H14-0020-24 – The Yews Farm Land off Spalding Road Pinchbeck Spalding PE11 3UE:

Details of site levels & floor levels, construction management plan & method statement, estate road phasing & completion plan, adoptable estate roads & footways, surface water drainage scheme, on-site foul water drainage works, cycle store, acoustic barrier, landscaping & tree planting, boundary treatments, management plan for areas of publicly accessible open space & outdoor play areas, management & maintenance schedule, additional elevational treatments for plots 1, 2, 11, 67, 68 & 69, external boxes for gas & electricity supplies, gas flues & soil vent pipes, preliminary ecological appraisal, swift next bricks, biodiversity management plan, local area for play (LAP) & water consumption (Conditions 3, 8, 9, 10, 11, 12, 13, 14, 15, 16, 17, 18, 19, 20, 21, 22, 23, 24 & 25 of H14-1218-21)

Lincolnshire Wildlife Trust wishes to register a **holding objection** on this application until the conditions placed on planning application H14-1218-21 are fully addressed.

Biodiversity Management Plan

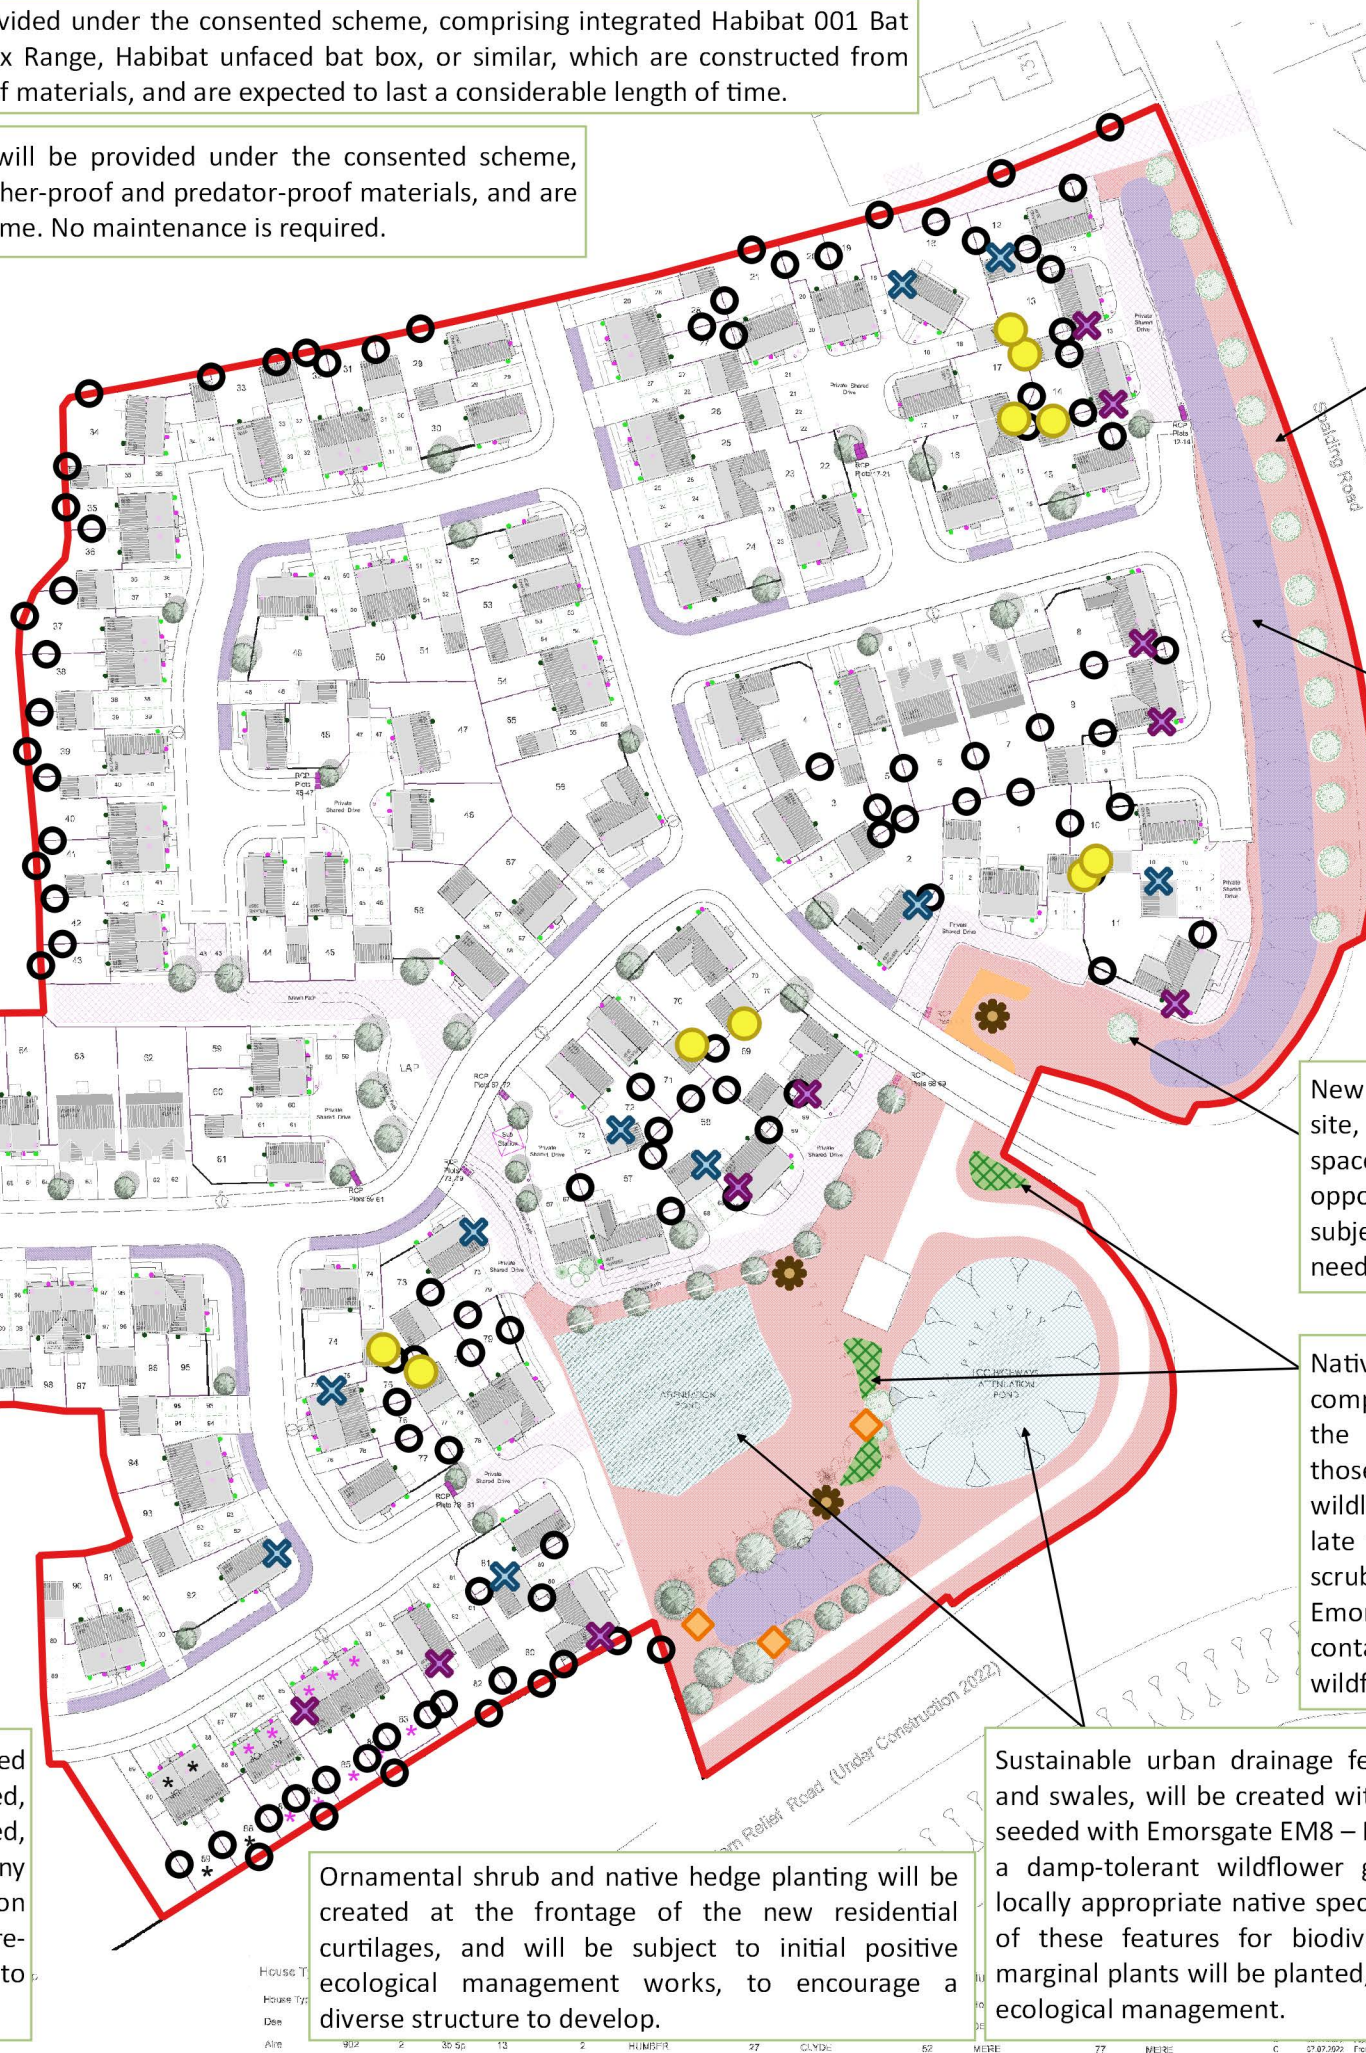
The Biodiversity Management Plan states that five swift nest boxes will be provided under the scheme, and no information on swift bricks has been included. This falls unacceptably short of the conditional habitat creation of three nest bricks per home.
